STERLING RANCH FILING 4

STREET IMPROVEMENT PLAN

MAY 2022

PENNYDALE DRIVE
STA 10+40.00 TO 16+50.00
 LOCAL PUBLIC ROAD

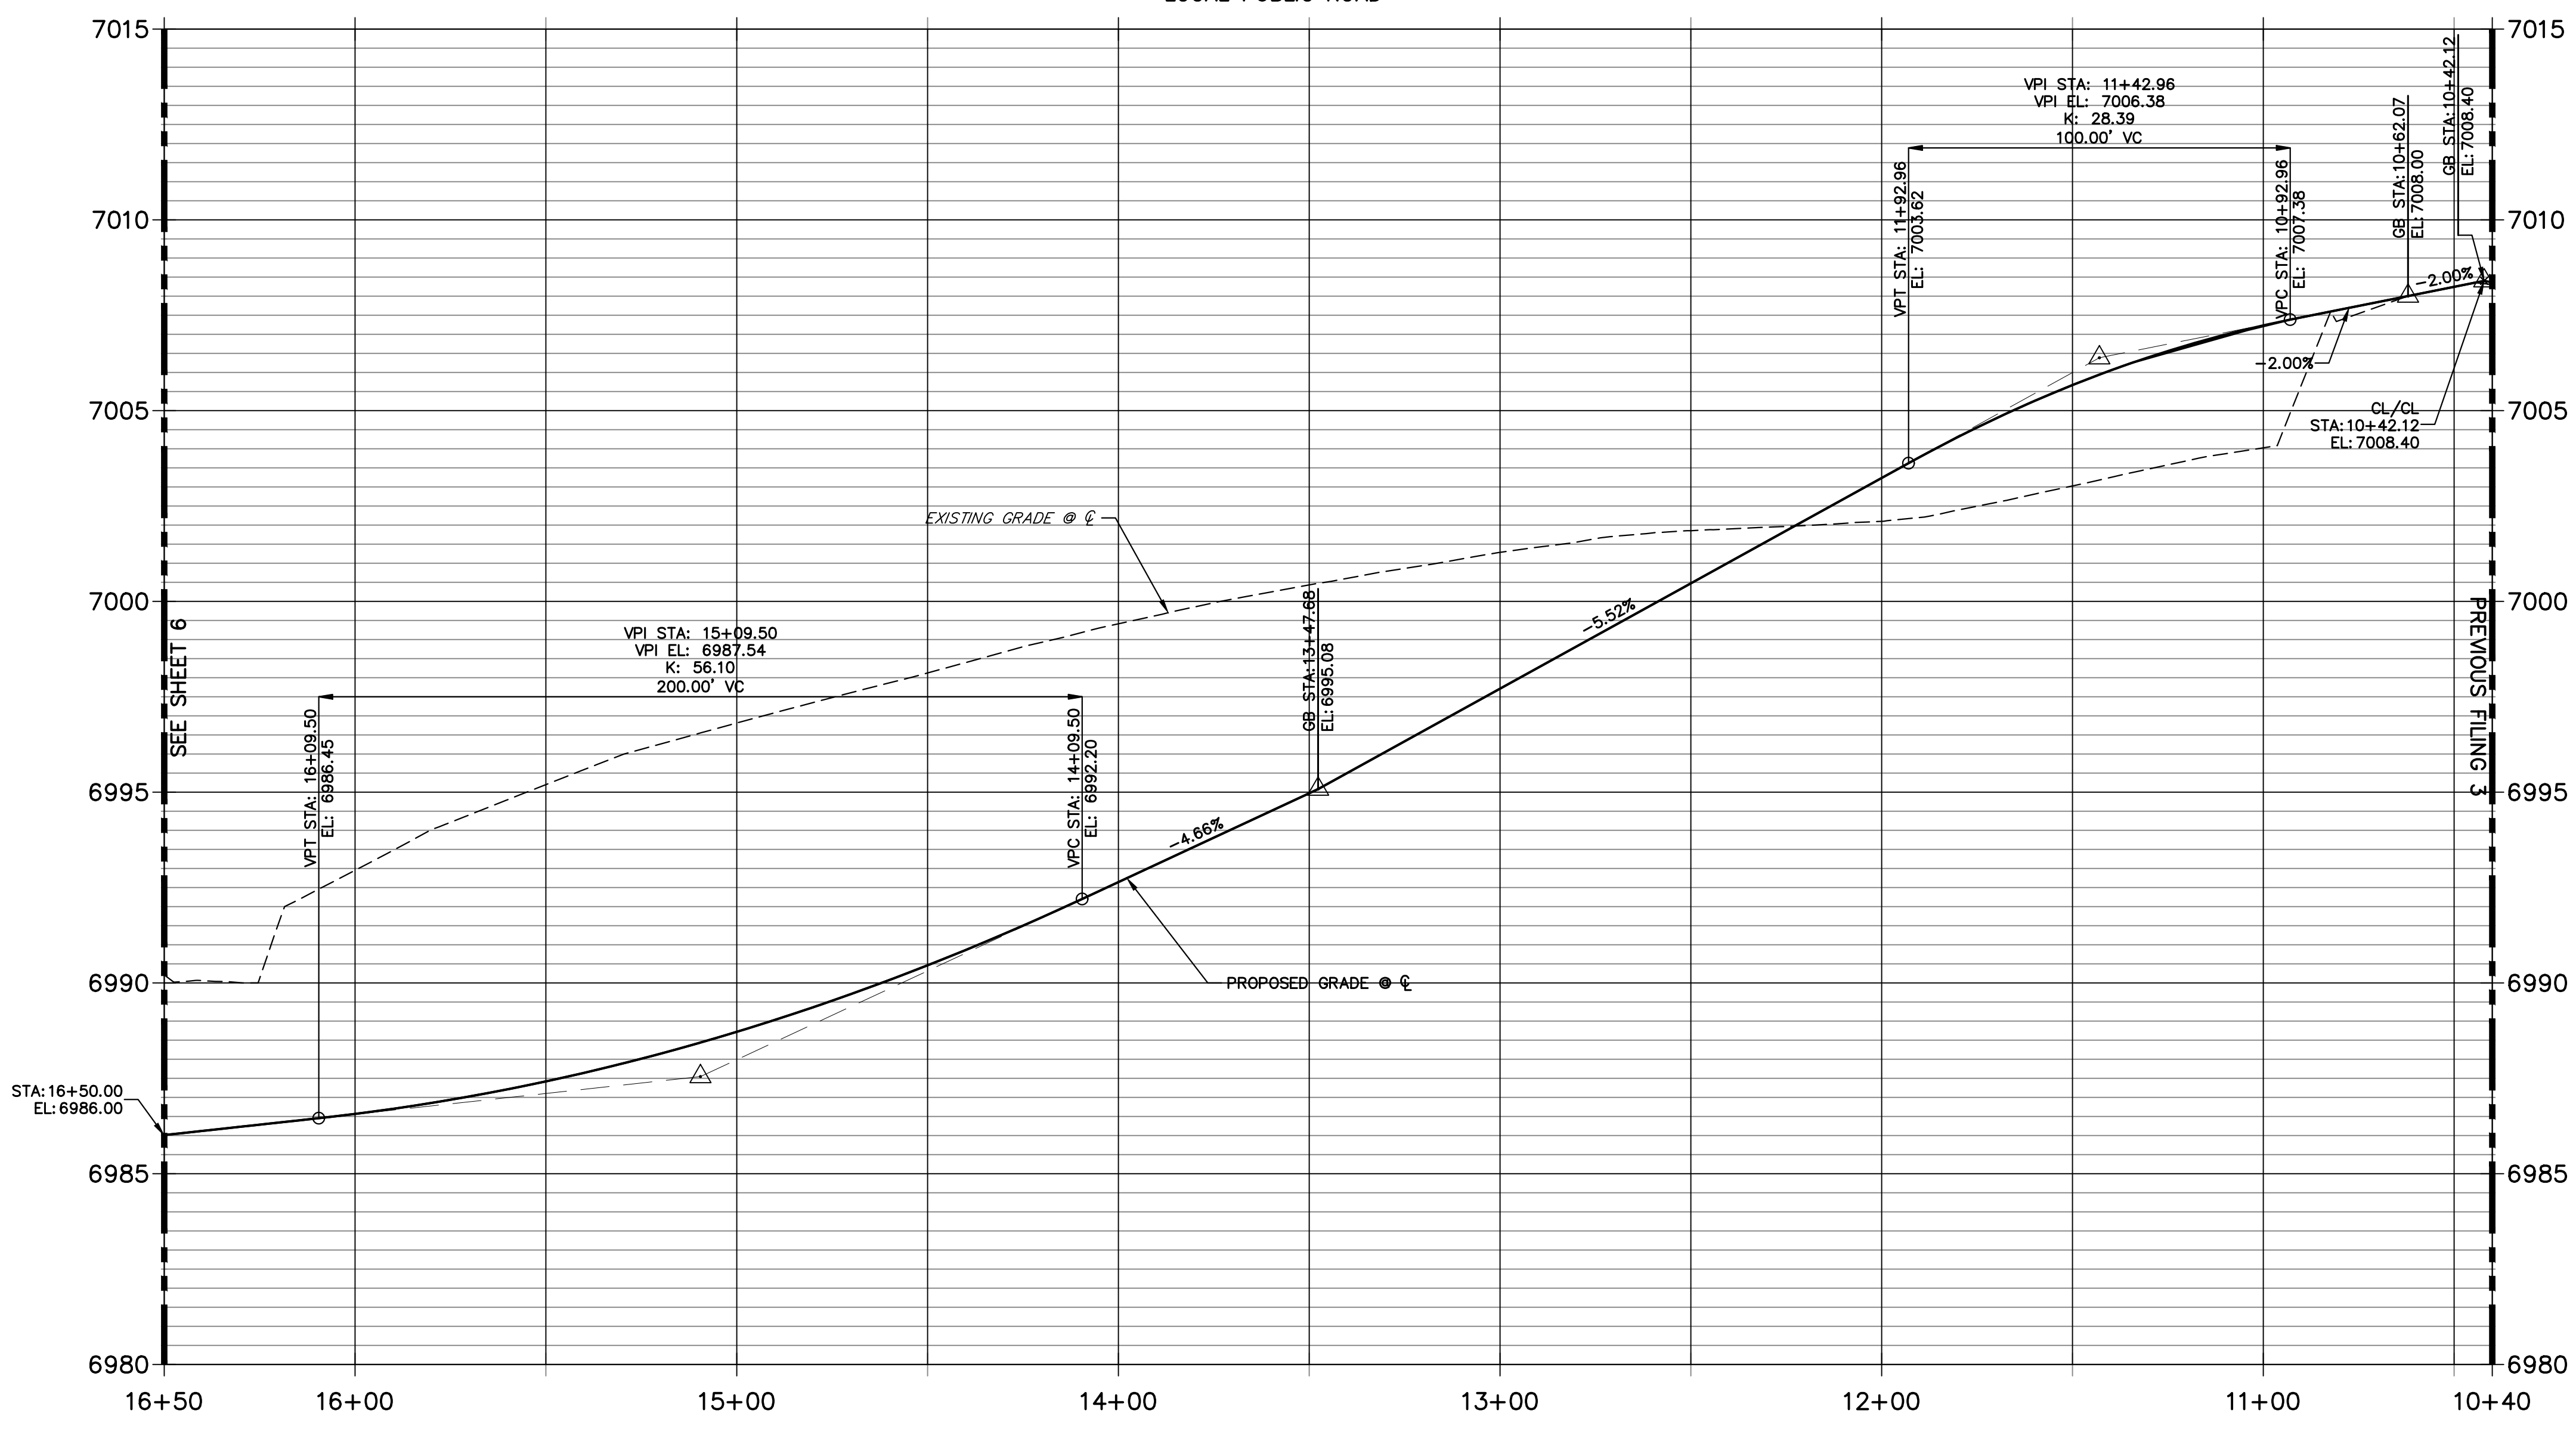
Add label to all sheets calling out local public road

label grade
